City of Portland, Maine - Building or Use Permit Application
 389 Congress Street, 04101 Tel: (207) 874-8703, Fax: (207) 874-8716

Permit No: 06-1382	Issue Date:	CBL: 064 A012001
------------------------------	--------------------	----------------------------

Past Use: Duplex	Proposed Use: Duplex/ after the fact- 100 sq ft shed - front sets on footings back of shed on Blocks	Permit Fee: \$30.00	Cost of Work: \$800.00	CEO District: 2
Proposed Project Description: after the fact- 100 sq ft shed - front sets on footings back of shed on Blocks		FIRE DEPT: <input type="checkbox"/> Approved <input type="checkbox"/> Denied	INSPECTION: Use Group: Type	
		Signature:	Signature:	
PEDESTRIAN ACTIVITIES DISTRICT (P.A.D.)				
Action: <input type="checkbox"/> Approved <input type="checkbox"/> Approved w/Condition <input type="checkbox"/> Denied				
		Signature:	Date:

12' x 8' 3/2" = 99.5 sq ft

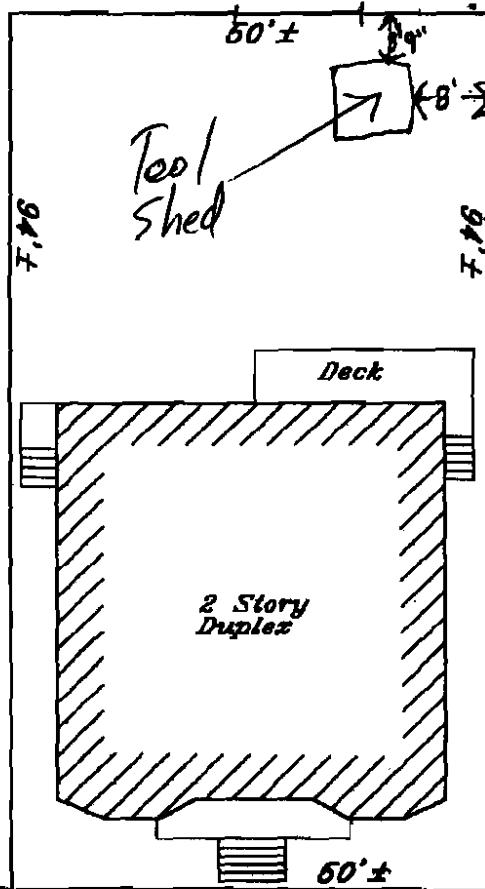
Dept: Zoning	Status: Approved with Conditions	Reviewer: Ann Machado	Approval Date: 09/27/2006
Note: Shed including the vinyl siding is 105.5 s.f. The actual frame without the siding is 99.5 s.f., so it falls under the accessory structure of 100 s.f or less and meets the setbacks.			Ok to Issue: <input checked="" type="checkbox"/>
1) This permit is being approved on the basis of plans submitted. Any deviations shall require a separate approval before starting that work.			
2) This property shall remain a two family dwelling. Any change of use shall require a separate permit application for review and approval.			
Dept: Building	Status: Approved	Reviewer: Tammy Munson	Approval Date: 10/10/2006
Note:			Ok to Issue: <input checked="" type="checkbox"/>
